Traffic Impact Study

Mayberry Communities

Filing 4 Traffic Impact Study

PCD File No. CS233 and SF2317

**FIGURE 8**  
SITE INTERNAL TRIPS

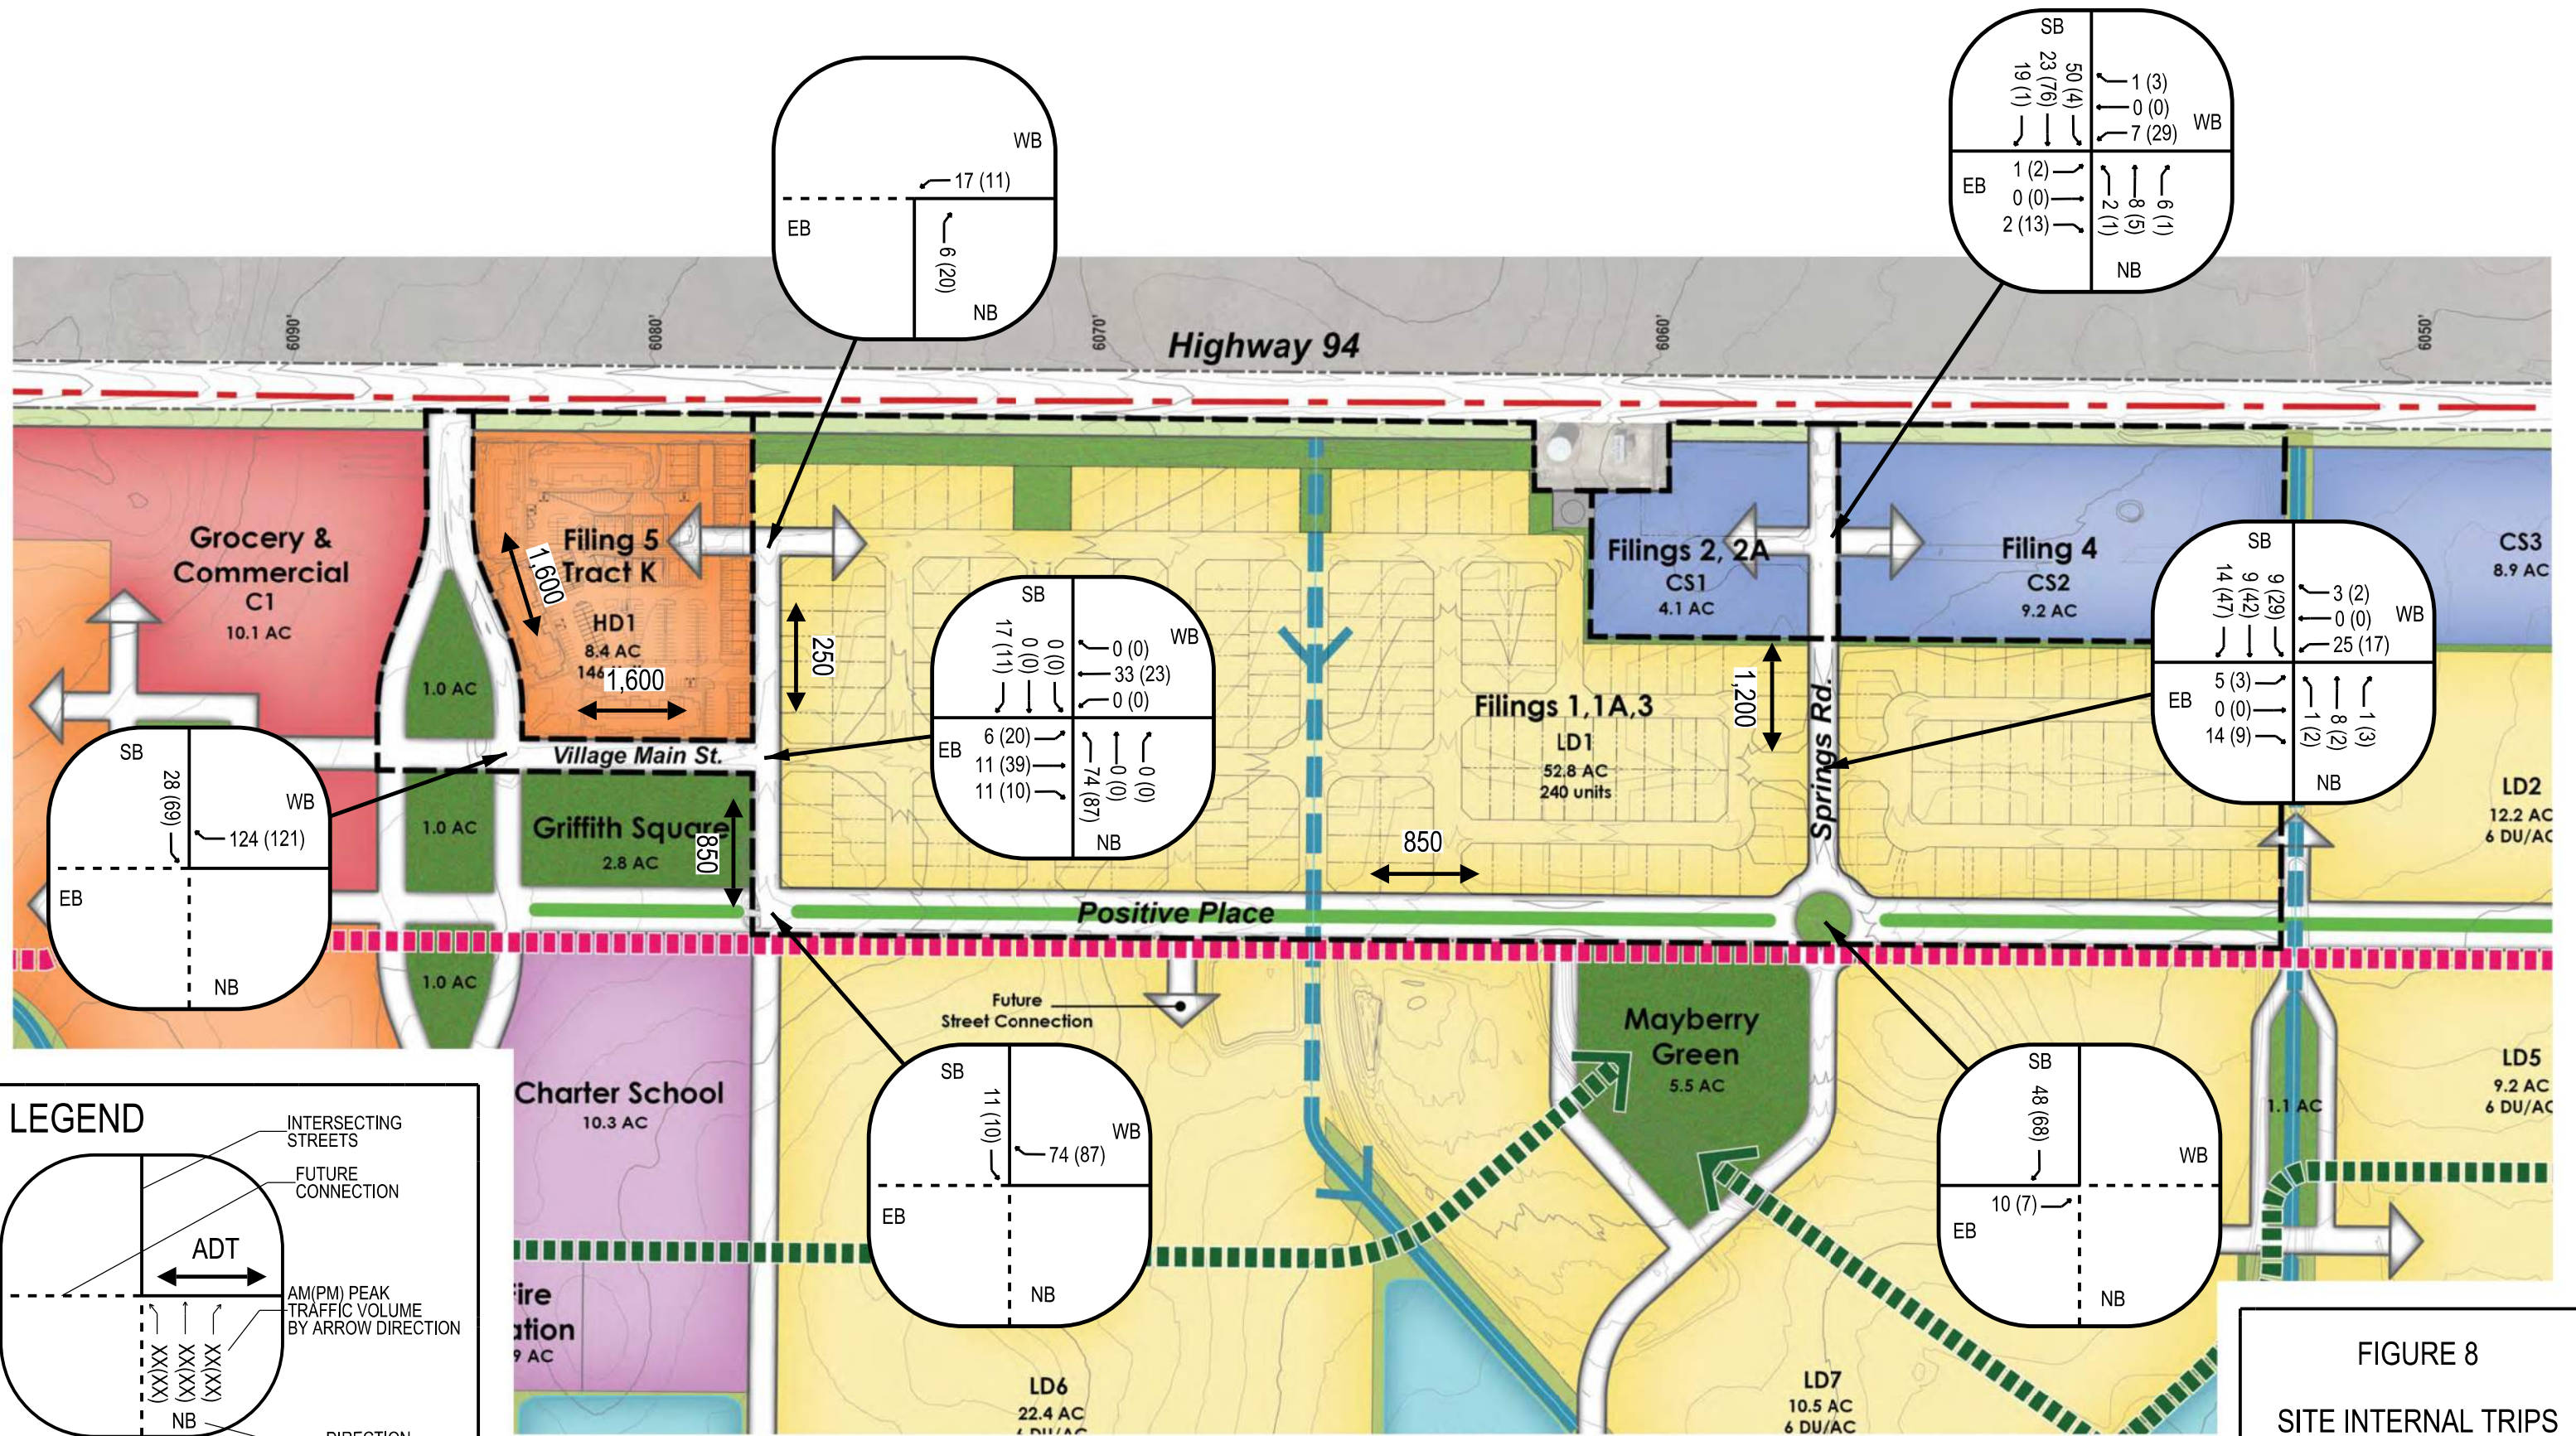
Unresolved: Address internal trips also. This includes traffic traveling to Mayberry Road to make left turns. Provide a plan showing the internal streets and intersections. If this was provided in the previous report, add that to the appendix of this report.
